Our ref: STH10/00063/12
Contact: Andrew Lissenden 0418 962 703
Your ref: SSD-3846

STATE SIGNIFICANT DEVELOPMENT (SSD) 3846 – PUBLIC AUTHORITY CONSULTATION – WEST CULBURRA MIXED-USE SUBDIVISION AMENDED CONCEPT PLAN

Transport for NSW (TfNSW, formerly Roads and Maritime Services) refers to the notification it received dated 19 January 2021 regarding the above State Significant Development (SSD) application.

Figure 12. The layout of the roundabout

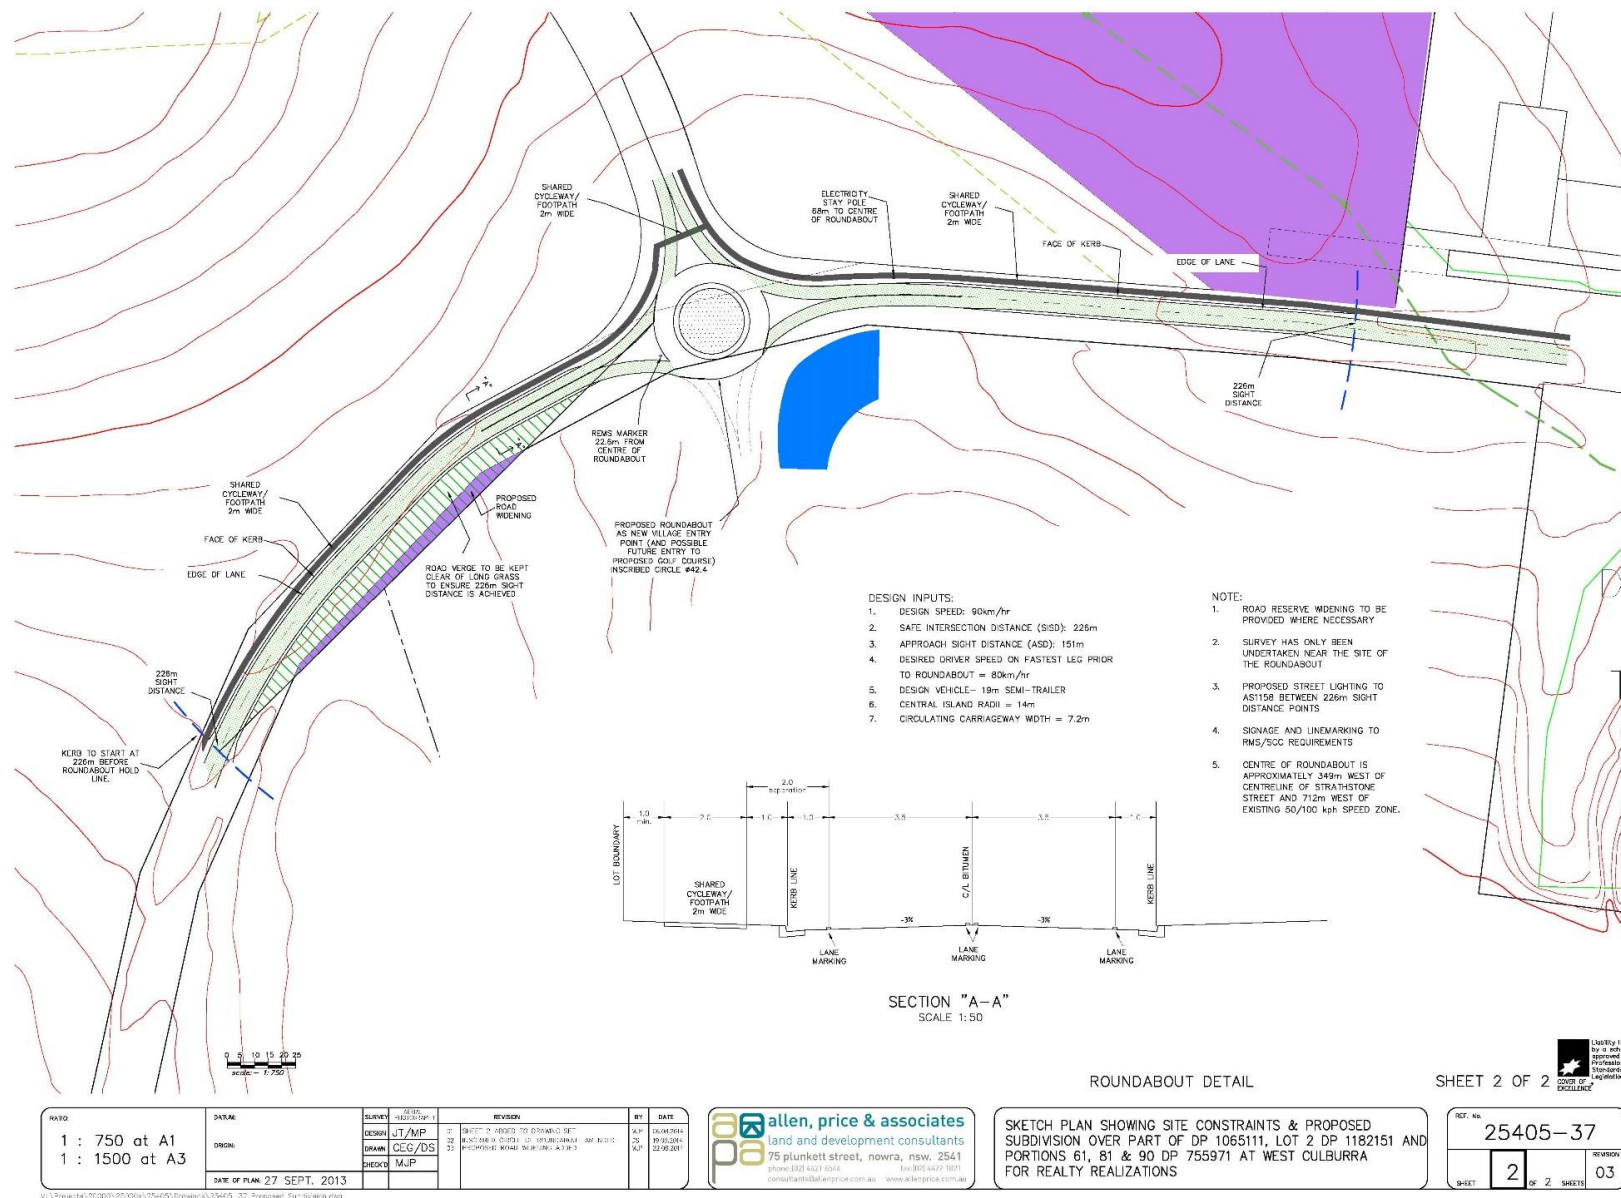
2. As identified in the submitted documentation, TfNSW is responsible for all permanent speed zoning in NSW regardless of the classification of the road. TfNSW is not supportive of roundabouts being placed in a speed zone over 80km/h. As detailed in its advice dated 15 August 2017 TfNSW would support a speed reduction to 80km/h (subject to formal assessment and approval) to facilitate the provision of a roundabout or roundabouts that provide consolidated access to the development.

3. The proposed roundabouts, if seen as an acceptable treatment should be designed and constructed in accordance with *Austrroads Guide to Road Design*, its associated supplements and technical directions. A design speed of 10km/h over the posted speed should be used for the designs (e.g. for a posted speed limit of 80km/h, the sight distance would need to comply with Austrroads standards for a 90km/h speed environment).

4. The roundabouts should be supported by a suite of measures on Culburra Road to reinforce the change of environment from a rural environment to an urban environment. This would need to commence on the eastbound approach to the roundabout and continue through the roundabouts into the existing township. This could include, but not be limited to street lighting, kerb and gutter, off-road paths and landscaping to reinforce the 80kph environment on the urban fringe. These measures would need to be provided for a distance equivalent to safe intersection sight distance. The proponent should identify and commit to a suite of measures on Culburra Road before the determination of the project.
